CITY OF ALBUQUERQUE

August 23, 2013

Re: **Hampton Inn At The Sunport Grading and Drainage Plan
Engineer's Stamp dated 7-29-13 (M15/D043)**

ENGINEER'S SEAL  DAVID SOULE P.E. #14522	HAMPTON INN @ SUNPORT	DRAWN BY WCWJ
		DATE 7-27-13
	GRADING AND DRAINAGE PLAN	21226-LAYOUT-7-05-12
	 Rio Grande Engineering 1606 CENTRAL AVENUE SE SUITE 201 ALBUQUERQUE, NM 87106 (505) 872-0999	JOB # 21226

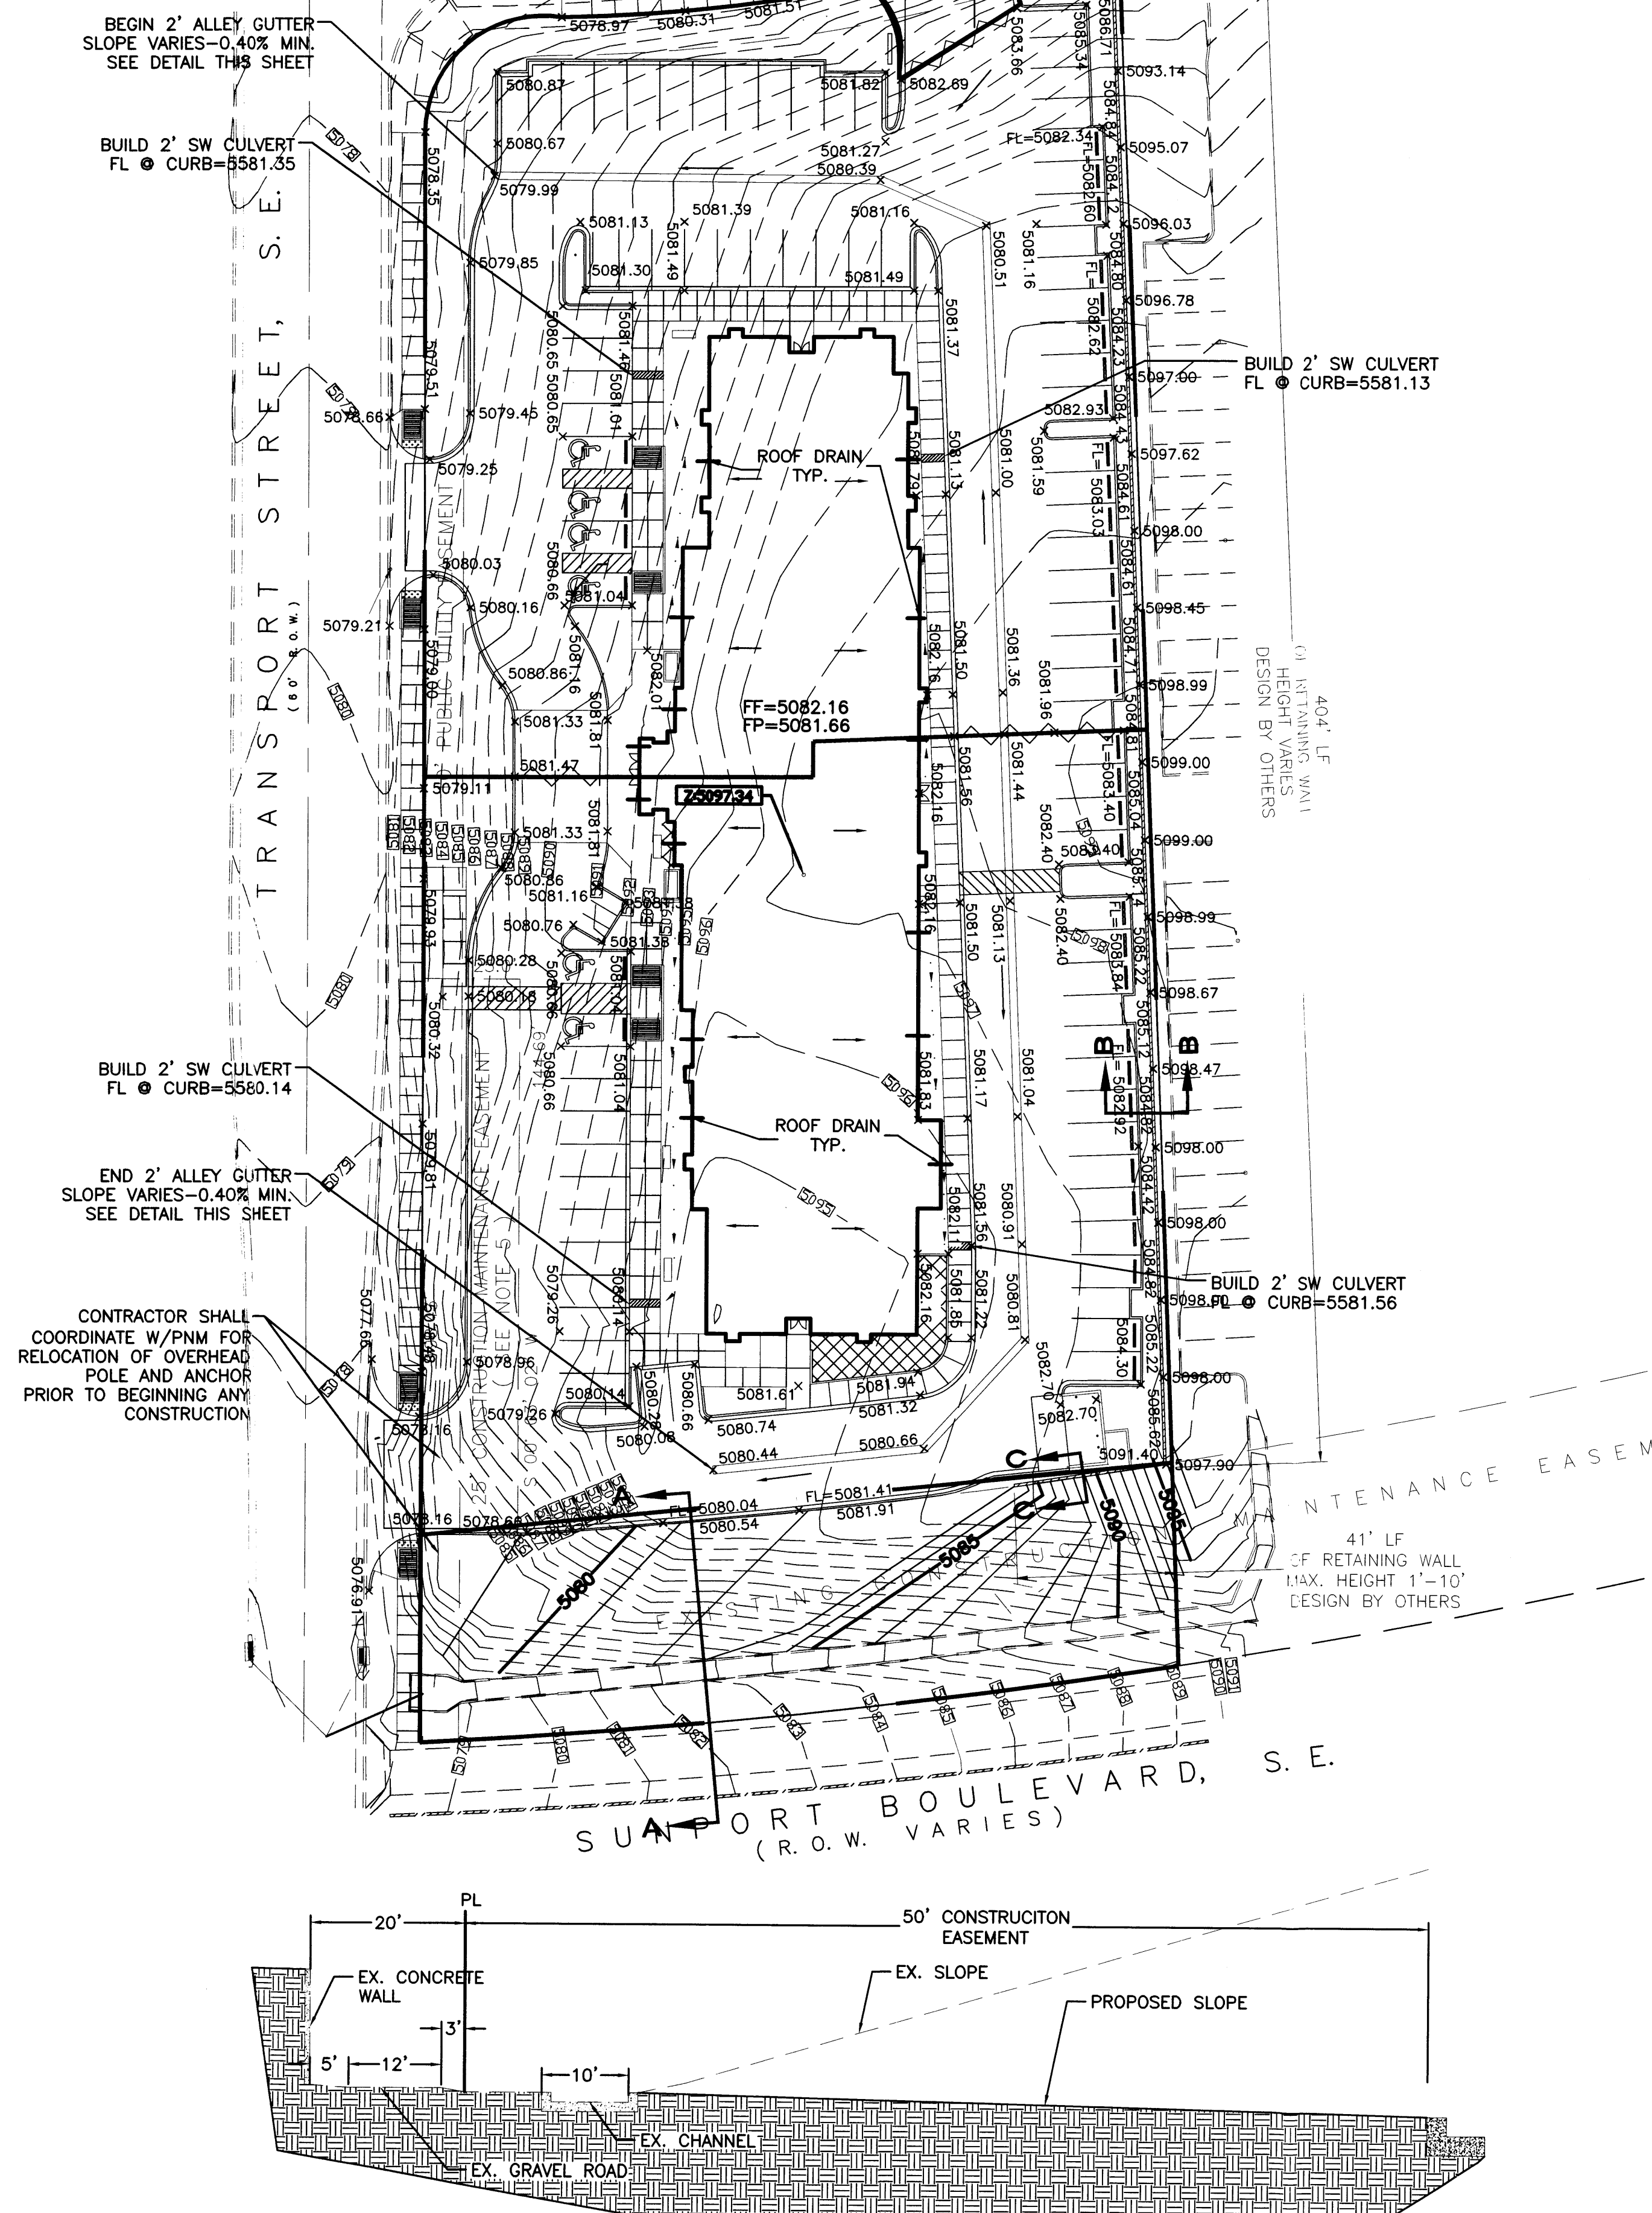
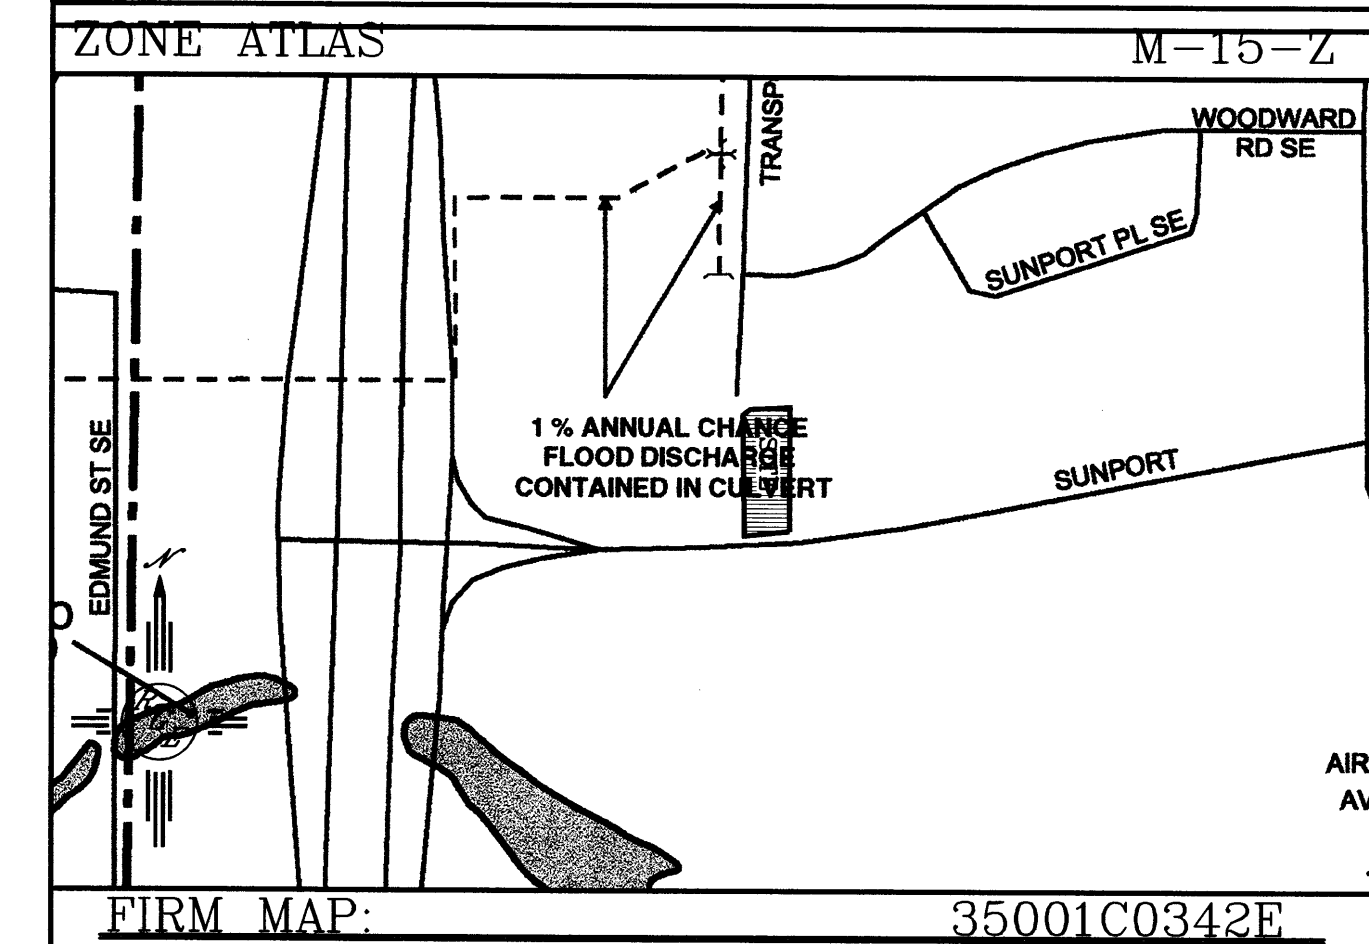
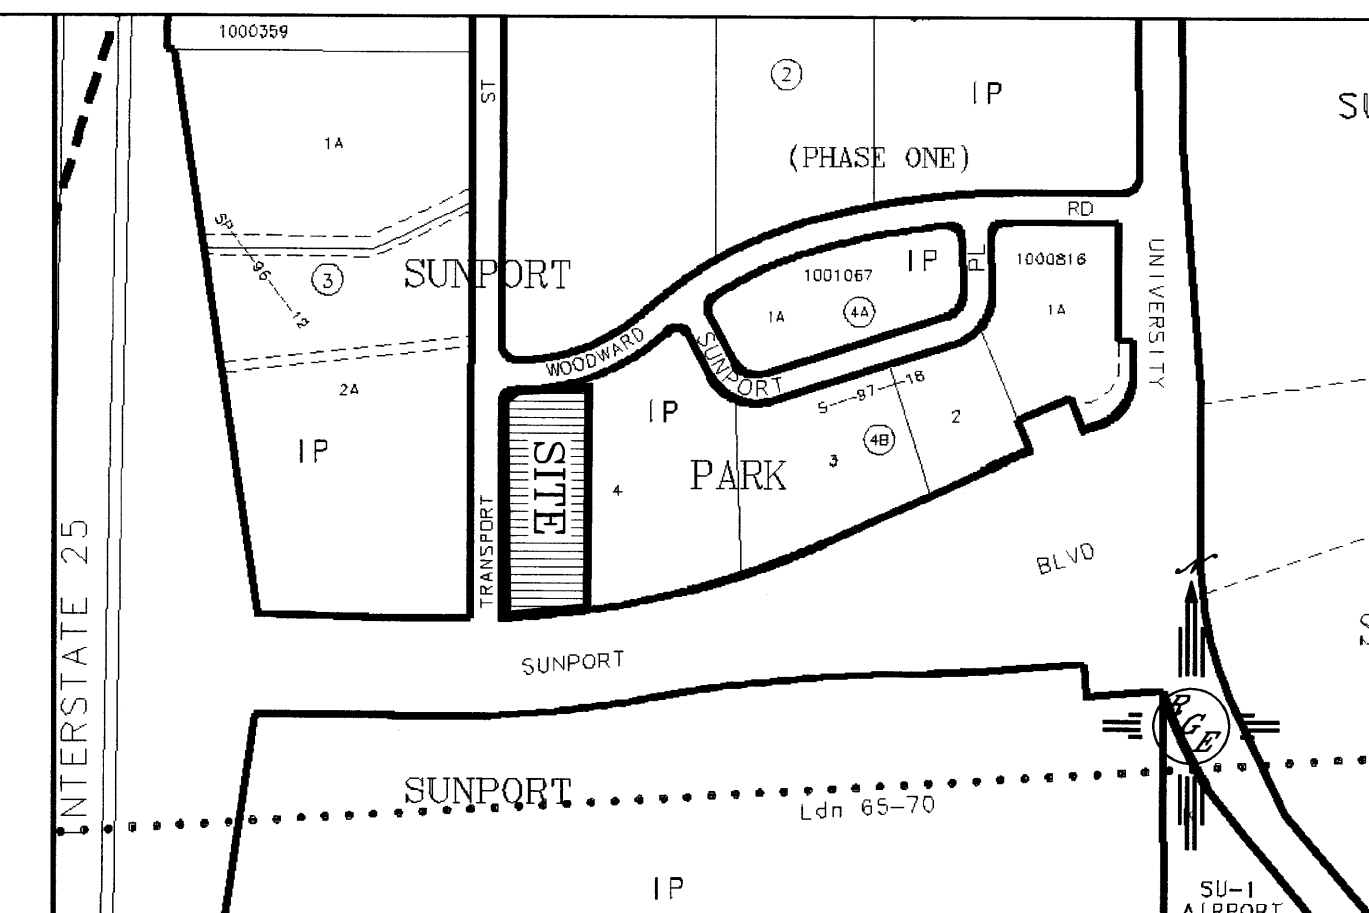
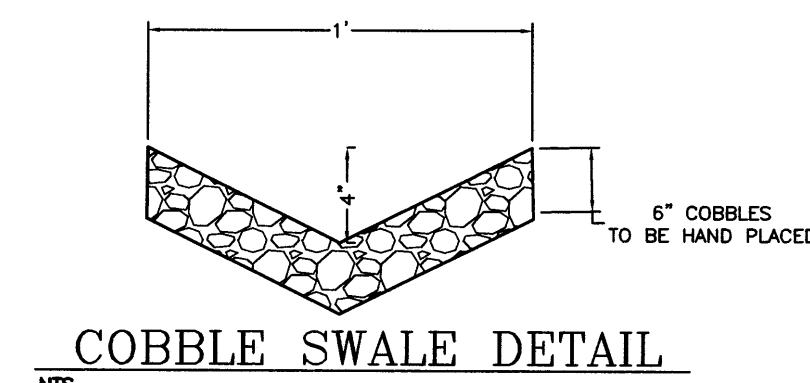
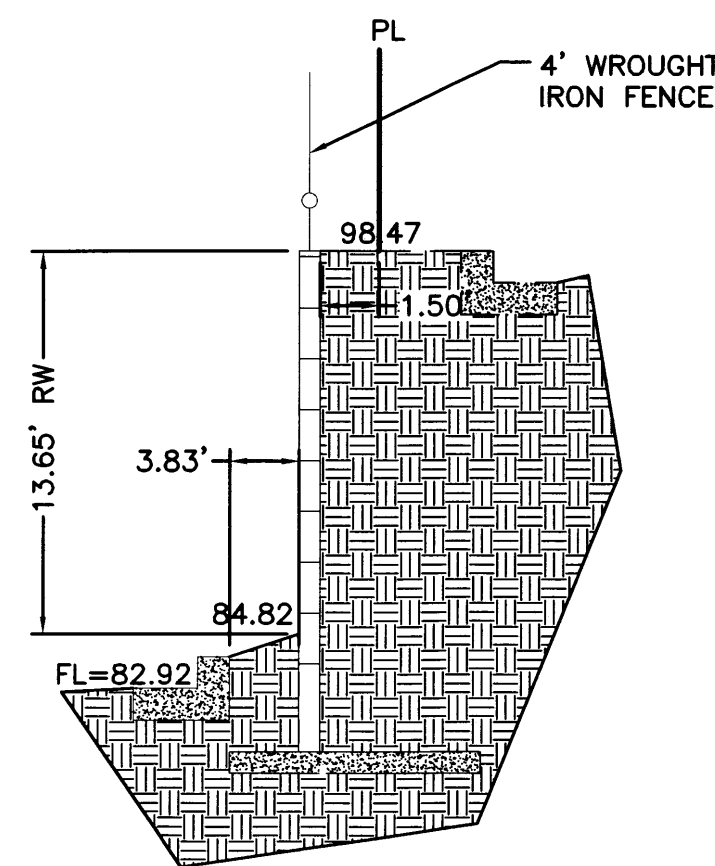
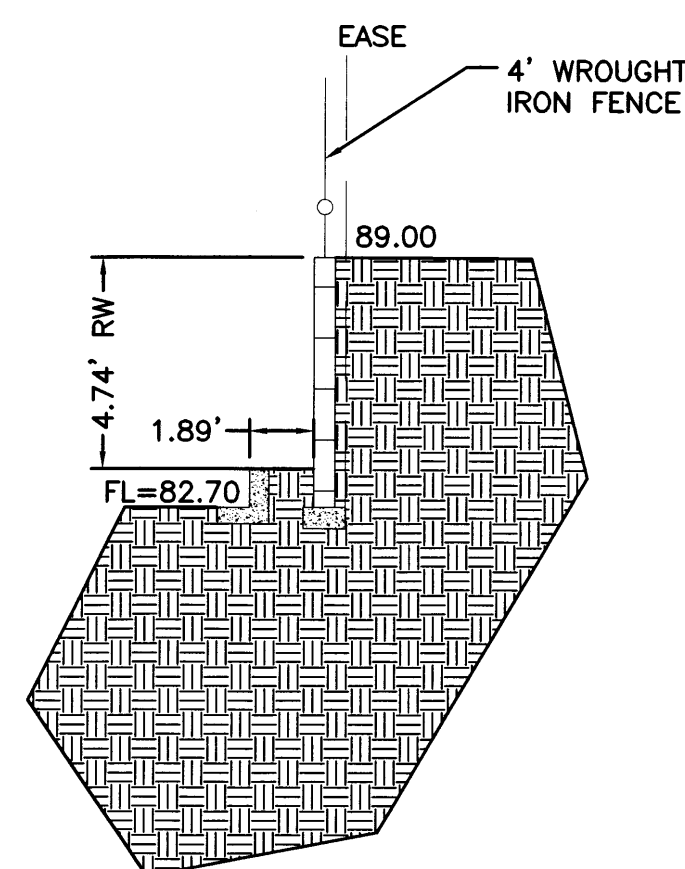
- Plot the existing contour at a lighter color and proposed contour at darker color. It is hard to see the proposed spot elevations.
- Revised grading plan should be approved by Wilfred Gallegos.

- Trash enclosure is not shown.
- Existing concrete wall along the southerly boundary is not shown on the plan. Section A-A is not drawn correctly.
- Section B-B should include the actual footing size for the retaining wall. How will the retaining wall be constructed? Construction easement will be required from the property owner to the east.

- Provide top of retaining wall and top of footing elevations.
- At the southwest corner of the project proposed contours extend to the adjacent property. Construction easement will be required.

- Provide more spot elevations along the alley gutter on the east side of the building. There might be low spots (by elevation 5081.00) on the east of the building.

- Fix the legend.
- Will there be any clear-sight distance issues with the eastern retaining wall being extended to the NE corner of the property?
- Include the City Benchmark on the plan.

- Show the location of the cobble swale on the grading plan or remove the detail if a swale is not needed.
- Remove the architect's stamp from the plan.

- Pedestrian connection to public sidewalk is not clearly shown.
